J.S. THOMPSON ENGINEERING, INC

May 13, 2021

The plan was reviewed for the Weatherly garage under construction in Angier, North Carolina to address two framing issues noted by the inspector. Analysis revealed the following:

SHEET 2 OF 4
 S-2
 SECOND FLOOR
 FRAMING PLAN

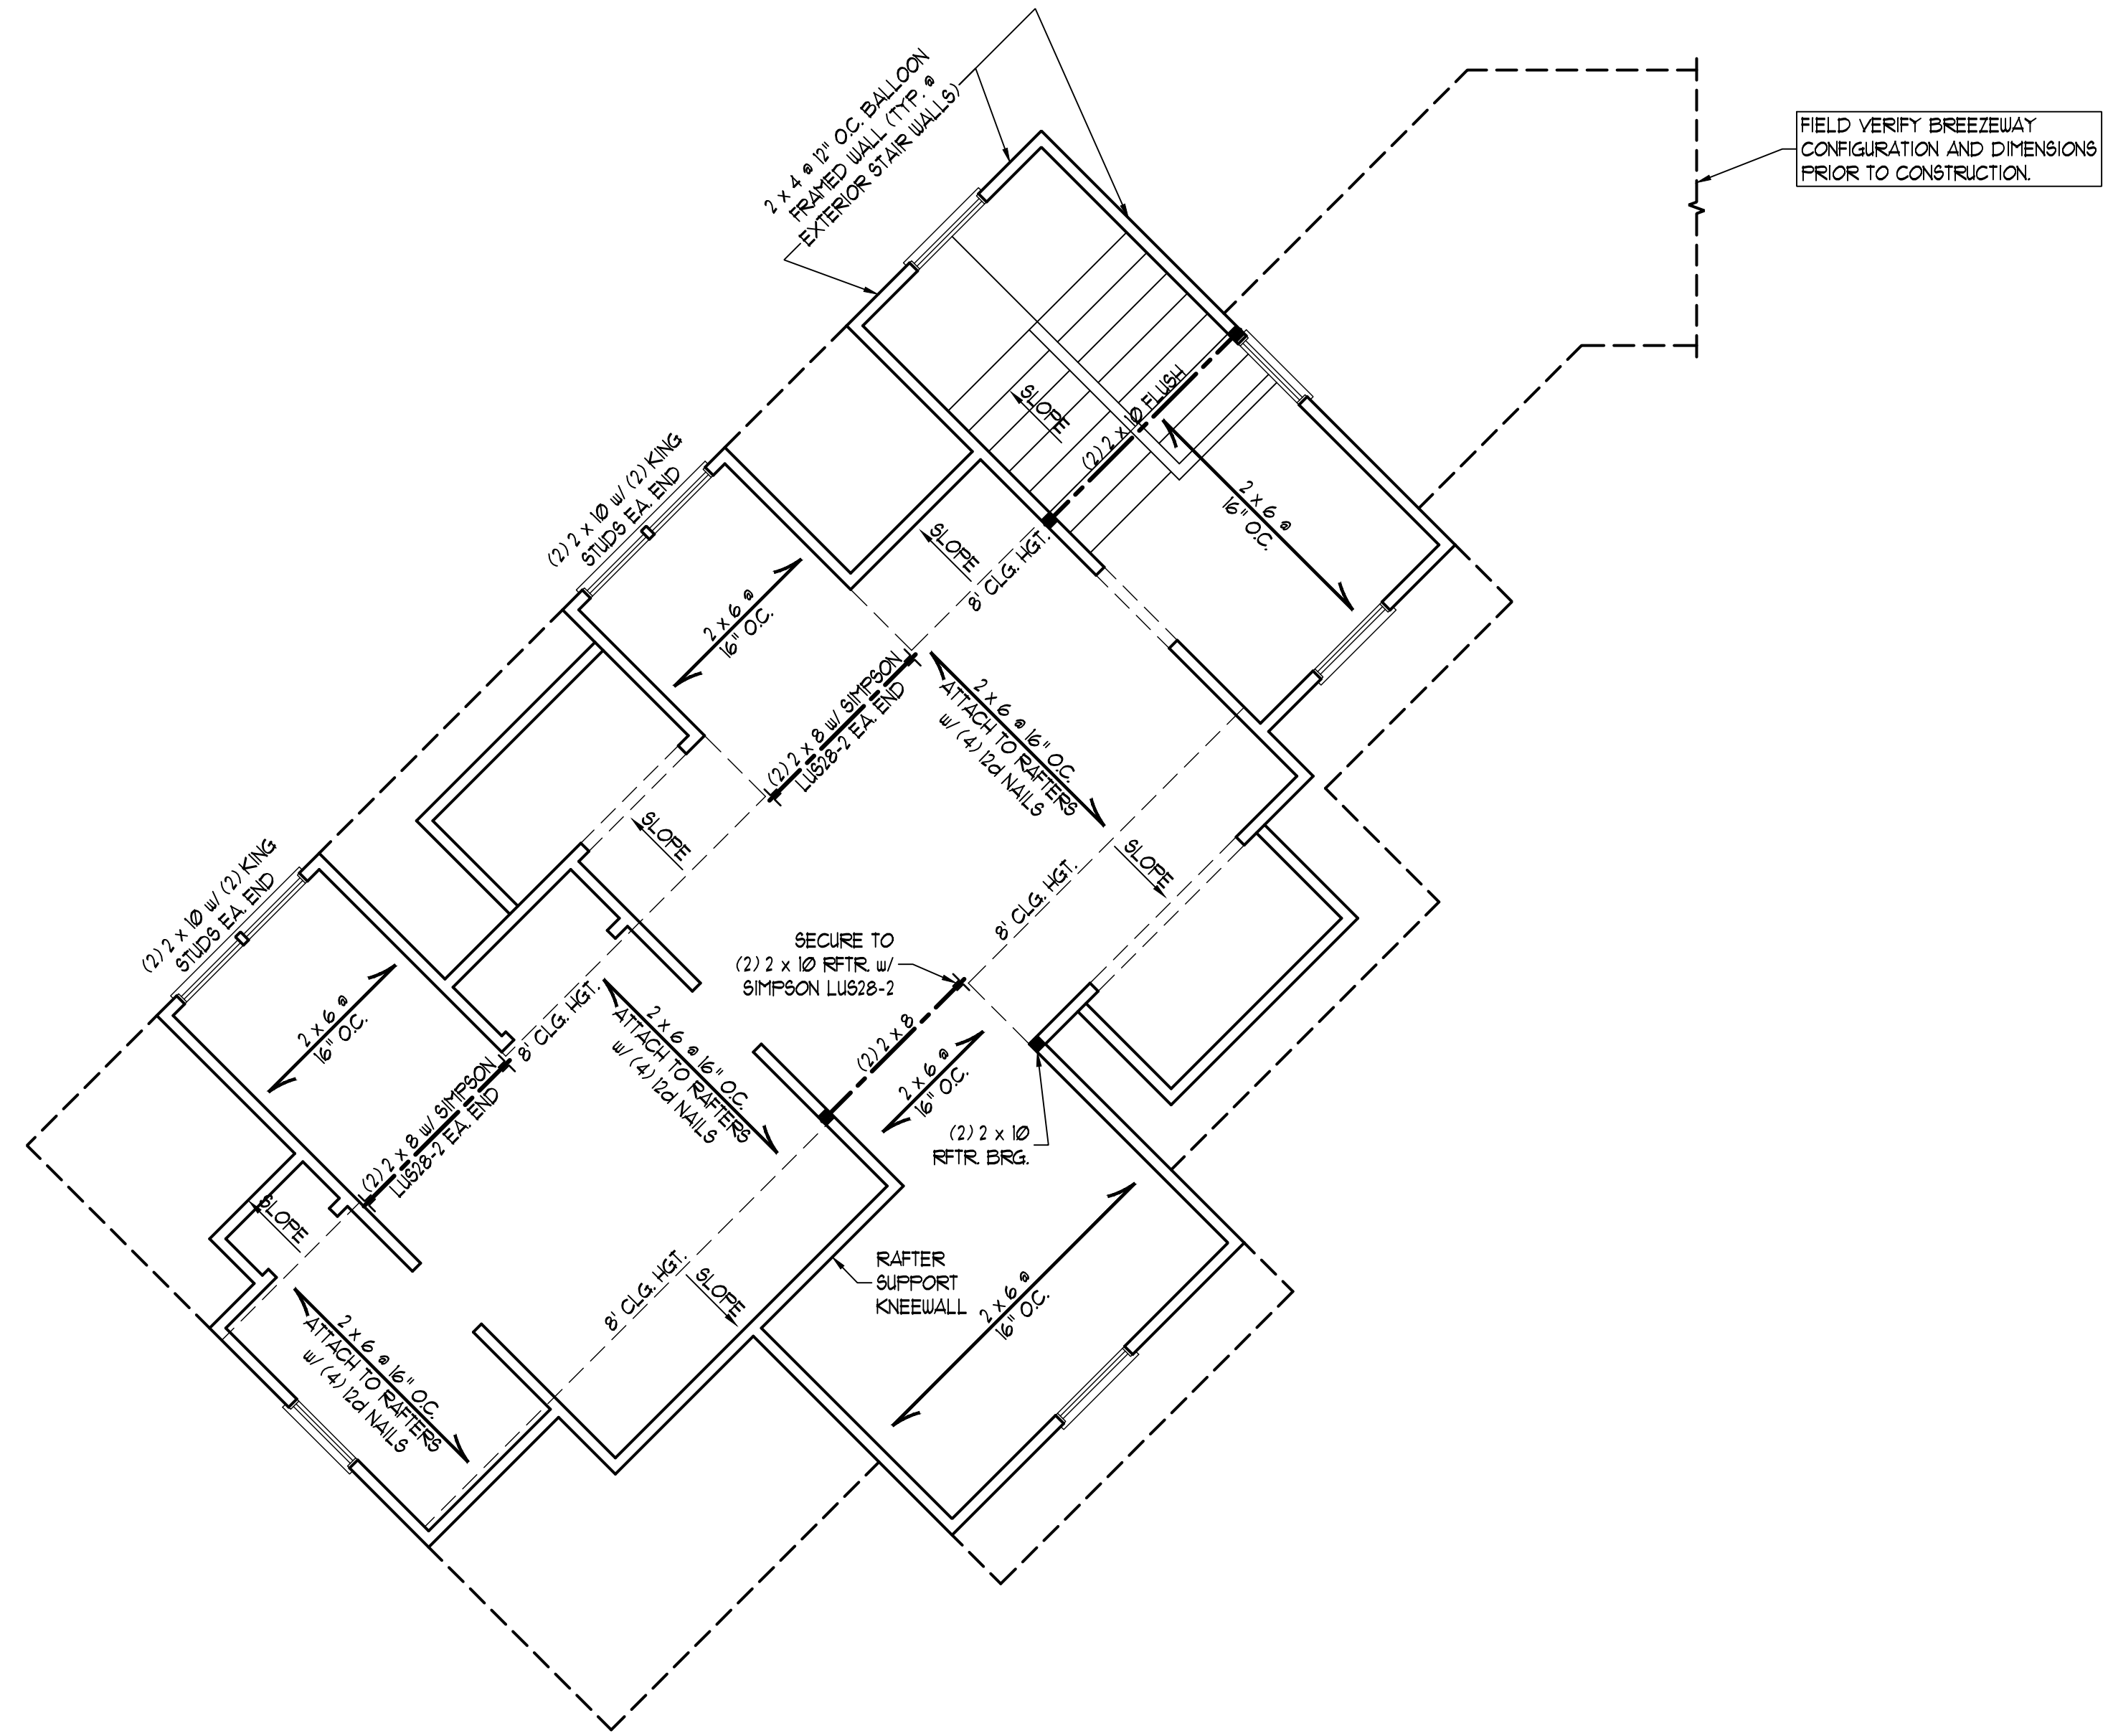
- 1) The Simpson LUS210-2Z hangers installed in lieu of the plan specified Simpson LUS28 hangers are sufficient.
- 2) The headers set at the top of the wall beneath the top plates with sections of wall suspended beneath are suitable. The "as-built" wall sections under the headers will support minimal loads imposed by vinyl siding and drywall and do not require modification.

This configuration will provide the required support for all applied loads.
